MU GROUP CONSULTING

TECHNICAL NOTE

**State Significant Development at 884-928
Mamre Road, Kemps Creek**

Ref: P21_19_APP_Mamre_WAD_DD

**Annexure 1 – LILO Strategic Design 2021\_19\_SD\_0001\_SK00014 Issue B**

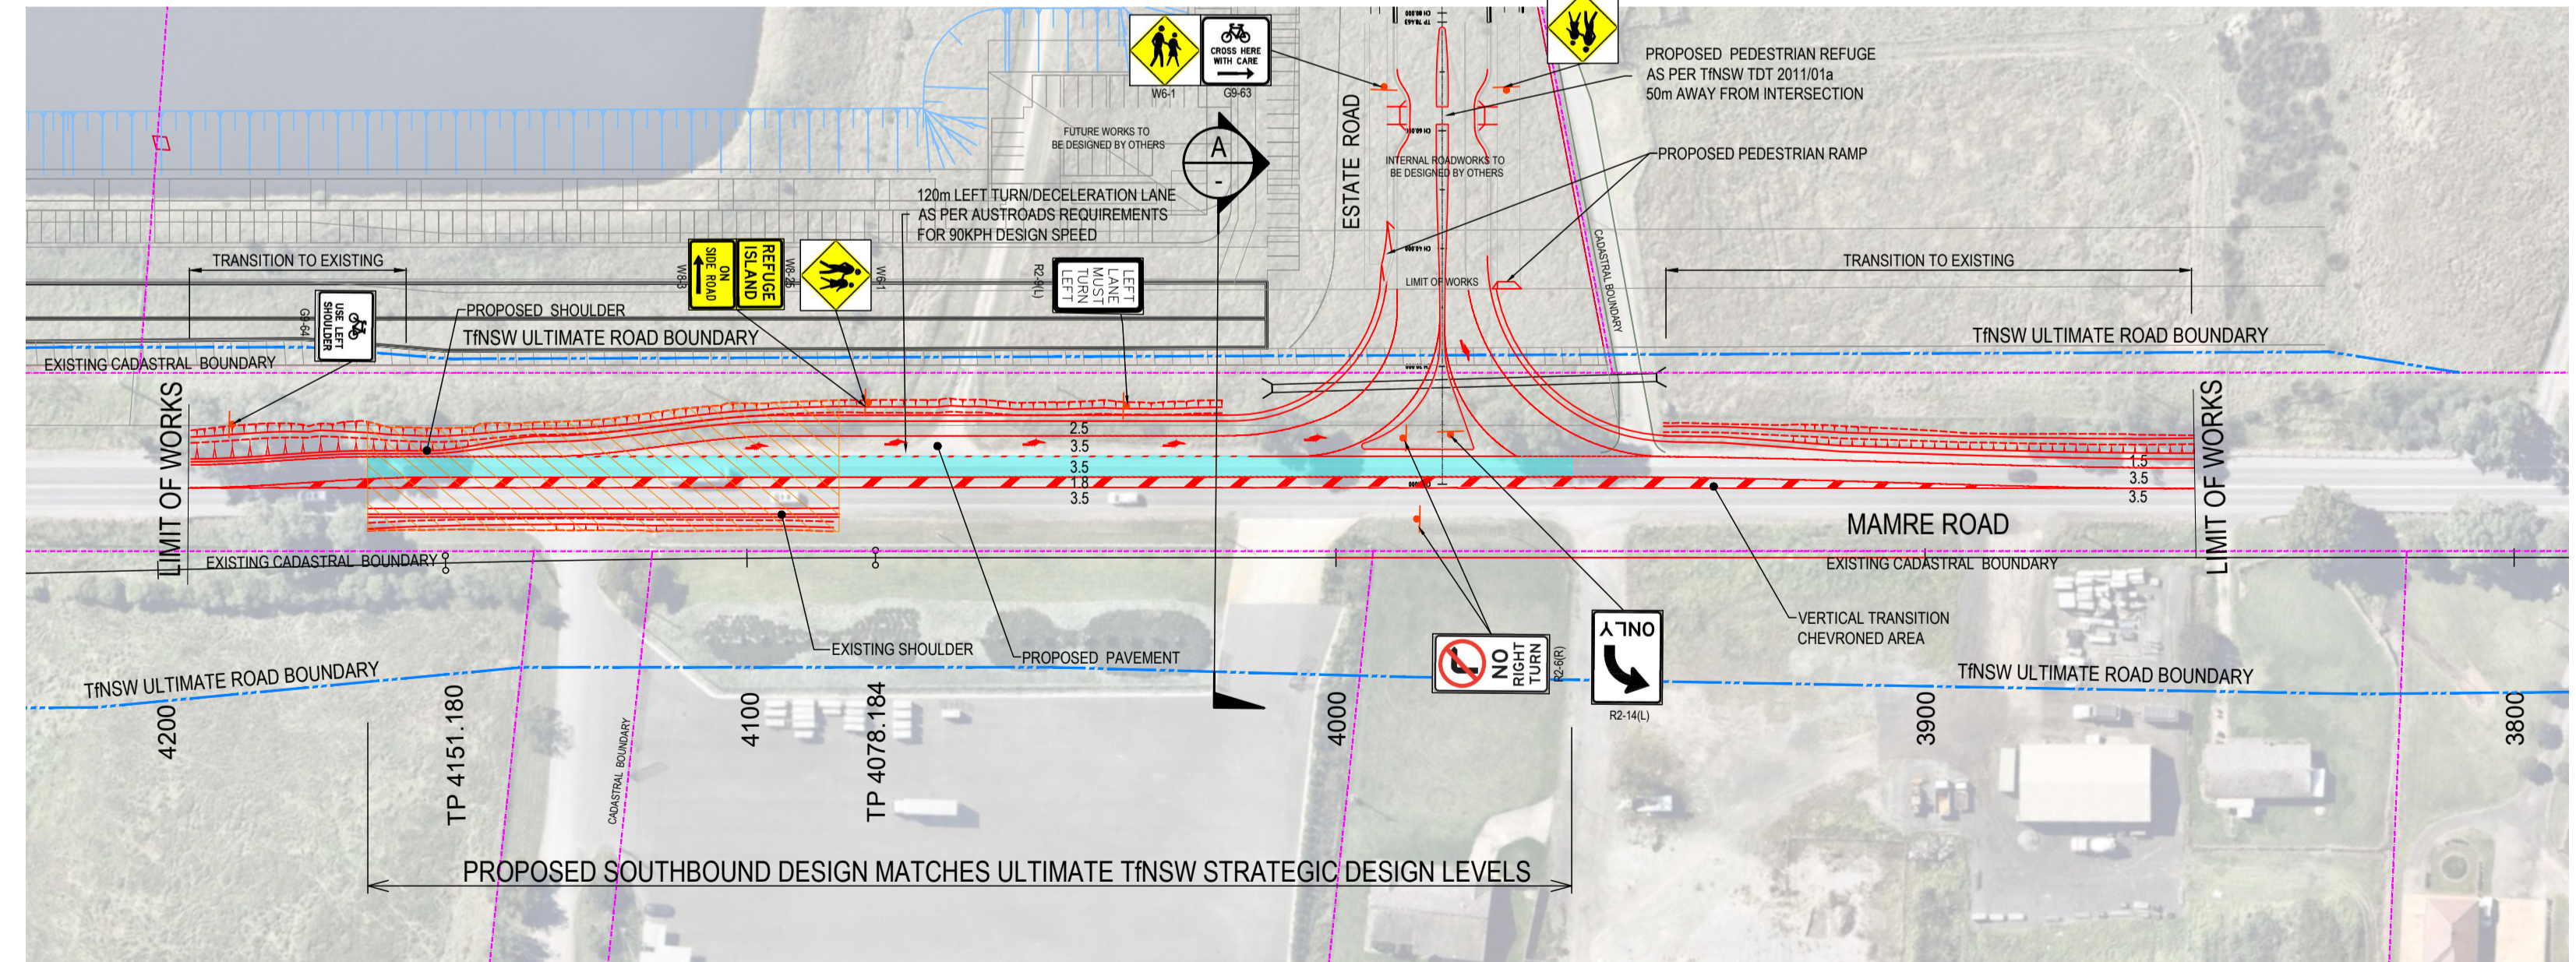
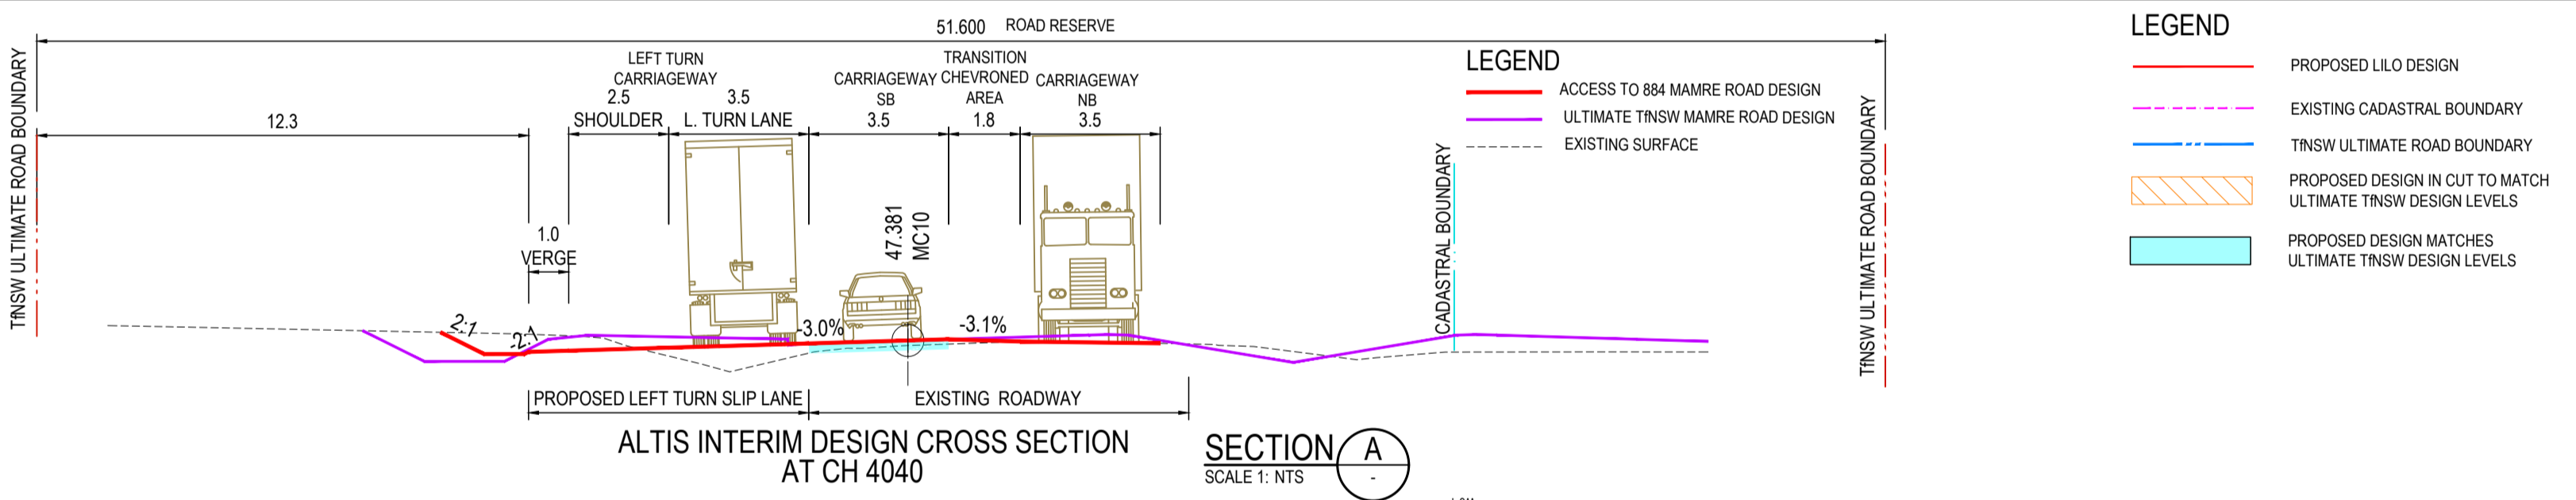
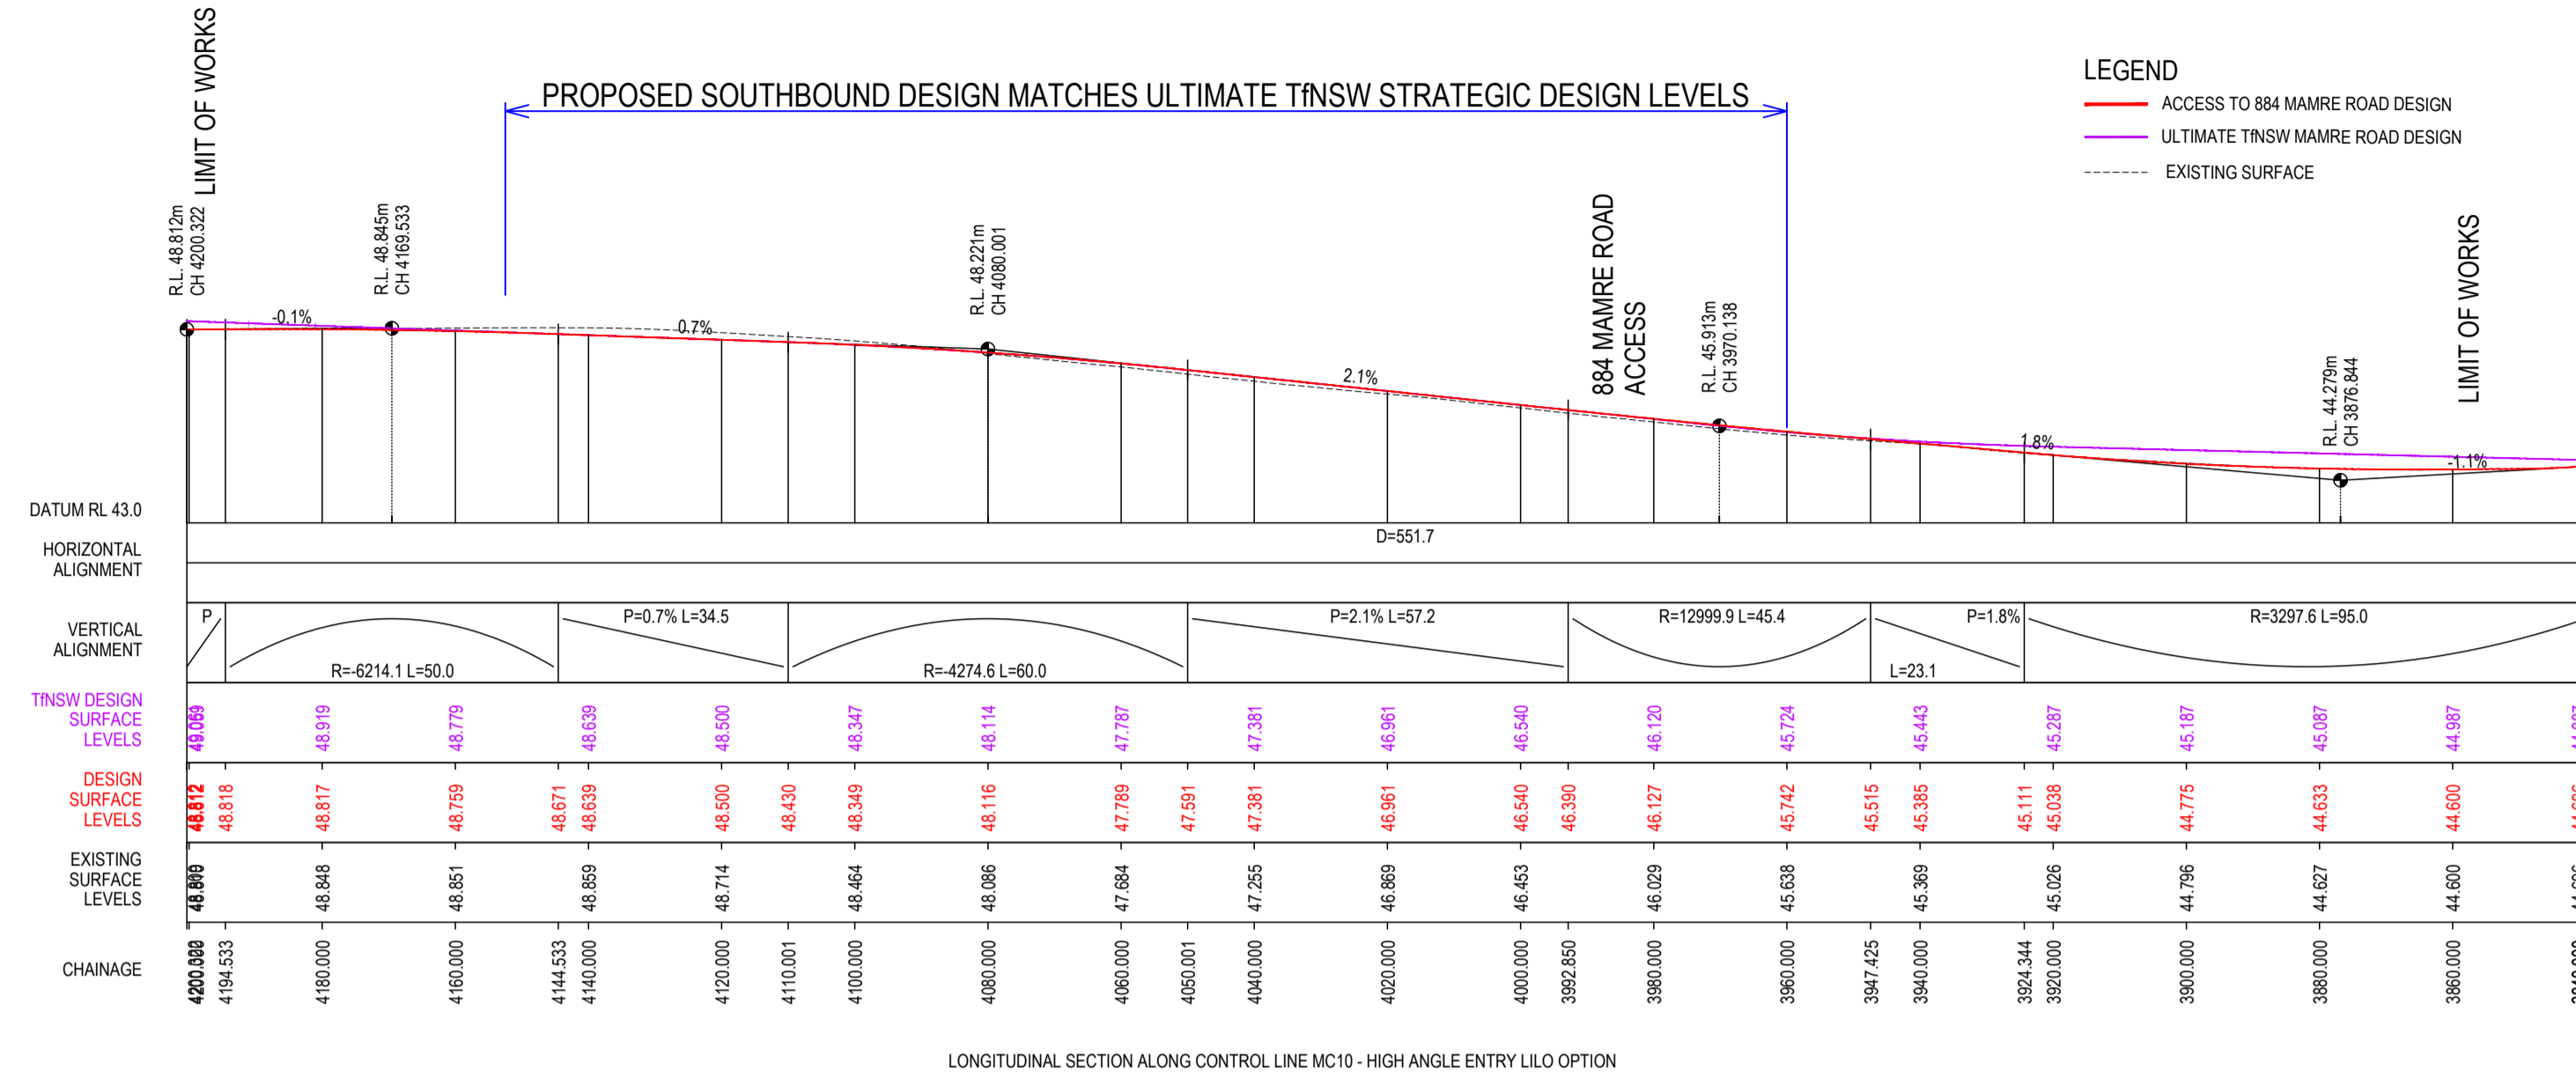
5. LILO is to be designed to physically restrict right turn movements at Mamre Road

The raised concrete median on the design has been extended to physically restrict or make it difficult for a vehicle to perform a right turn movement at Mamre Road. This is supported by the installation of a regulatory sign R2-6(R) No Right Turn (Refer to **Appendix C**).

**Annexure 2 – Acceleration Design (Stage 2) 2021\_19\_SD\_0001\_SK00017 Issue A**

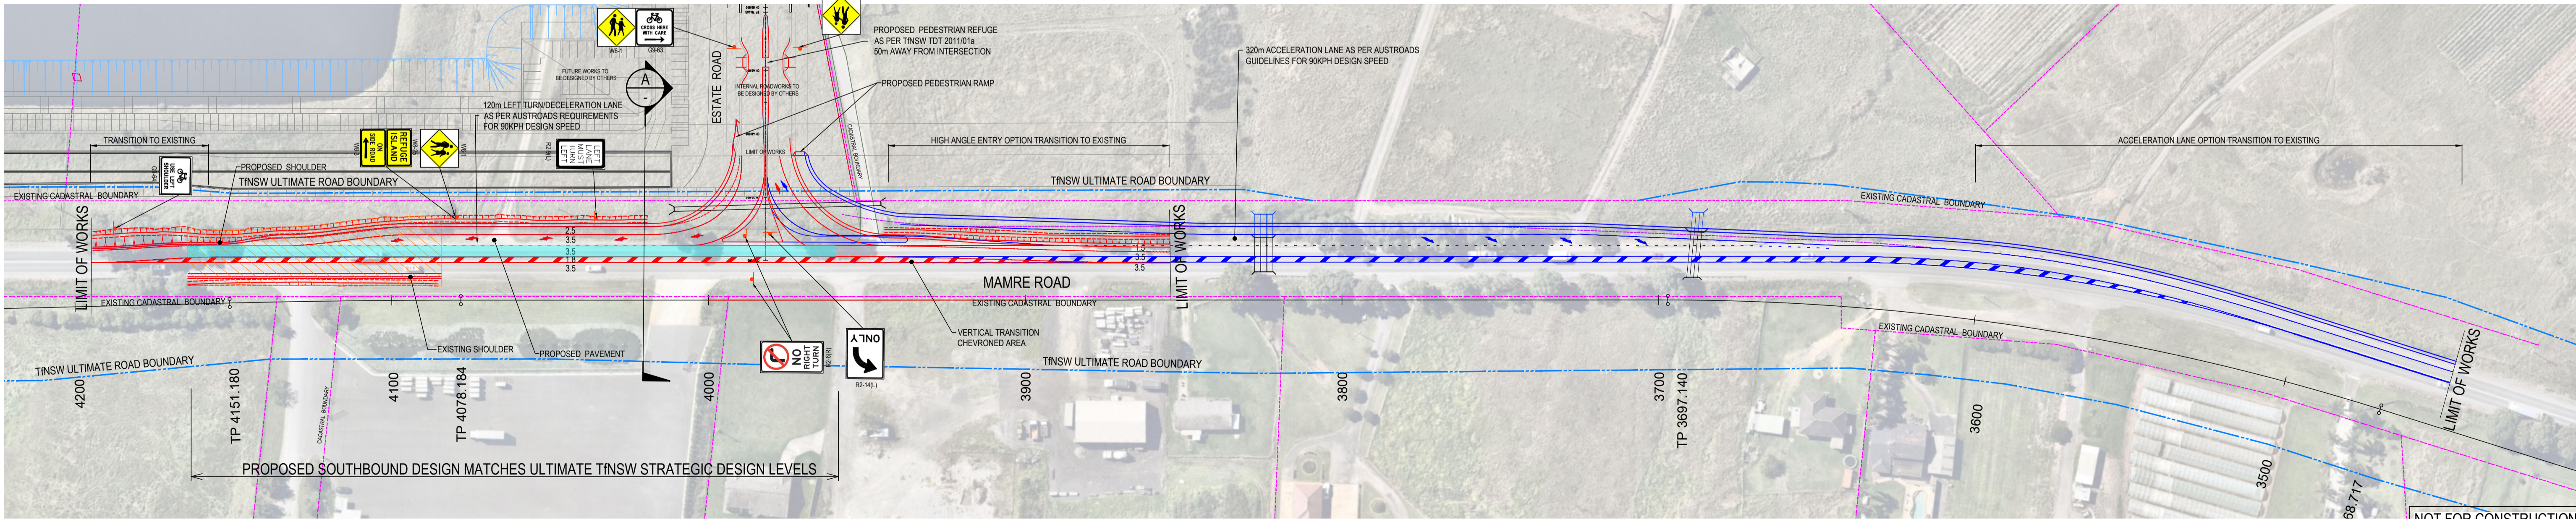
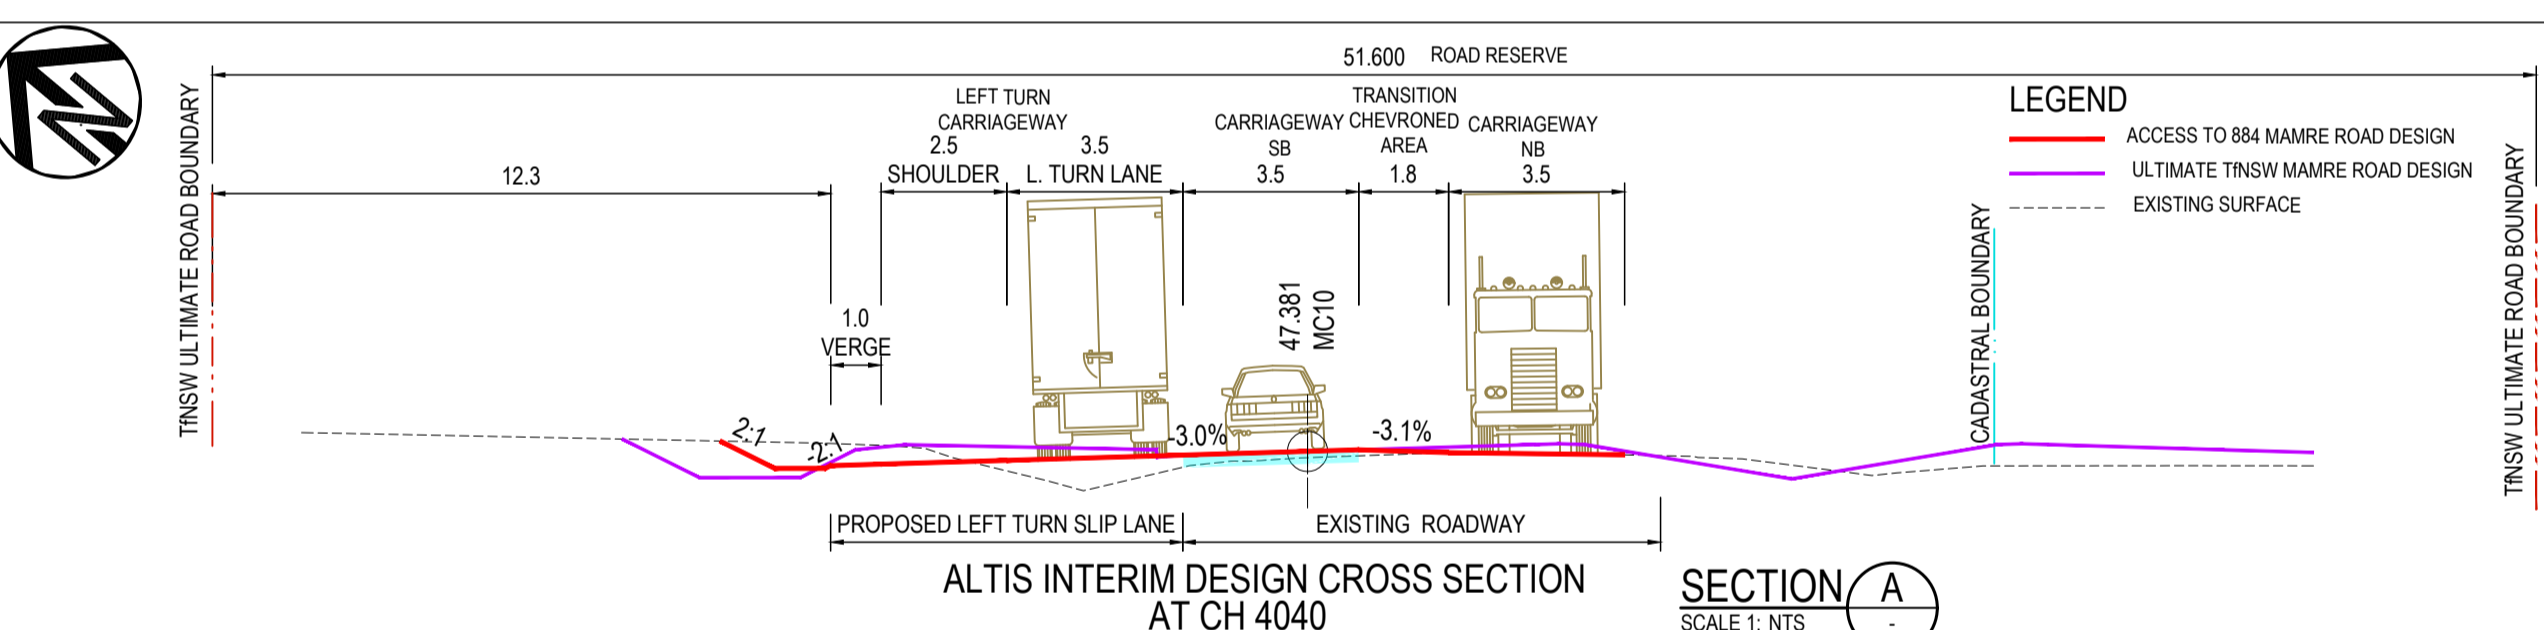
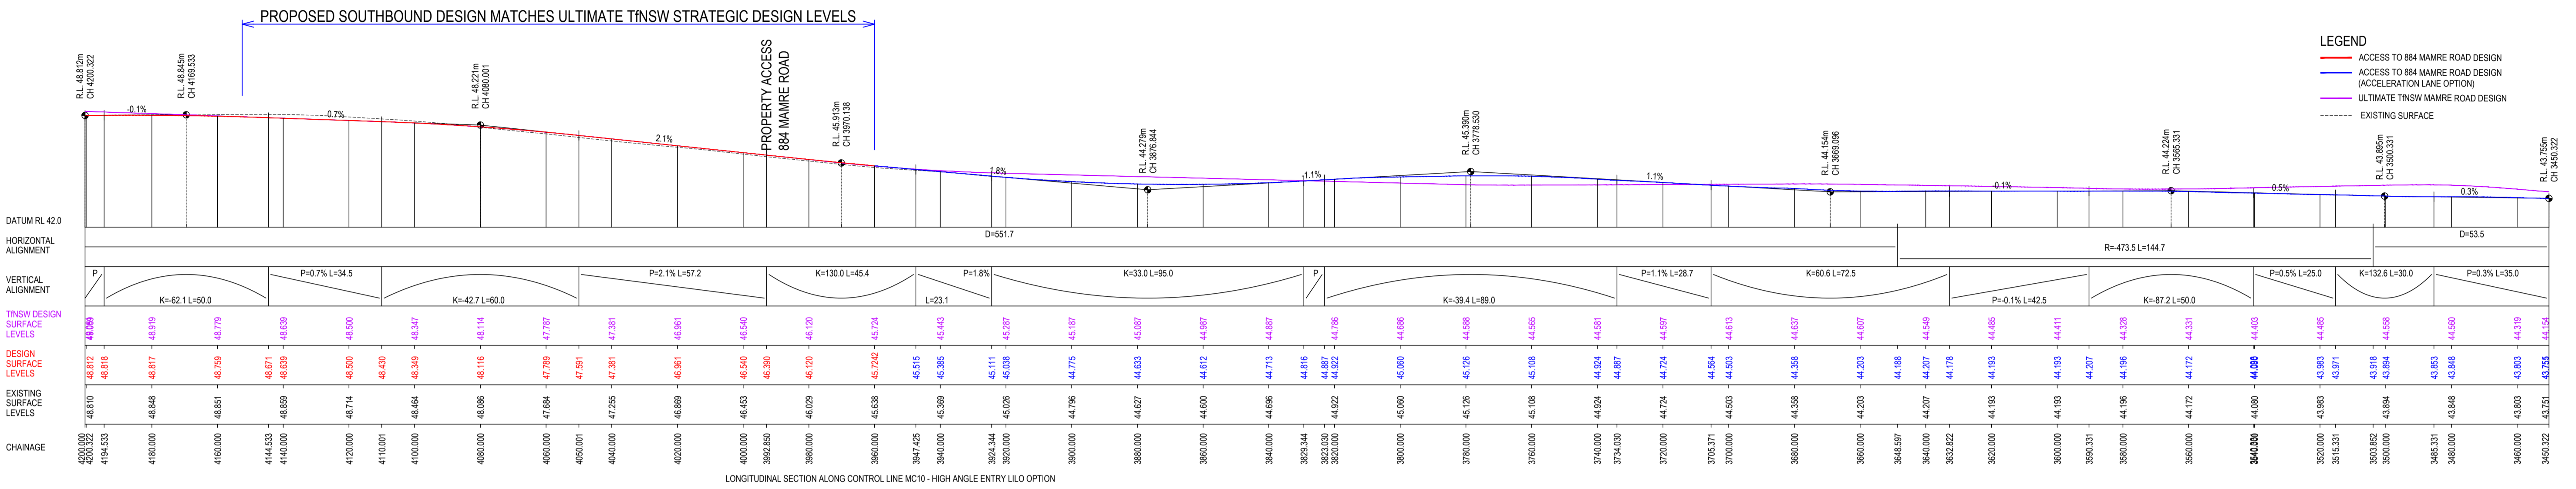
3. The length of the acceleration lane at this location is considered too short and would not be supported on this ground.

The length of acceleration lane in the strategic design is **320m, which complies with Table 5.7 of Austroads Guide to Road Design Part (AGRD) 4A**. This is based on the acceleration lane length for semi-trailers to a specified decrement of 20km/h below the through lane speed of 80km/h.
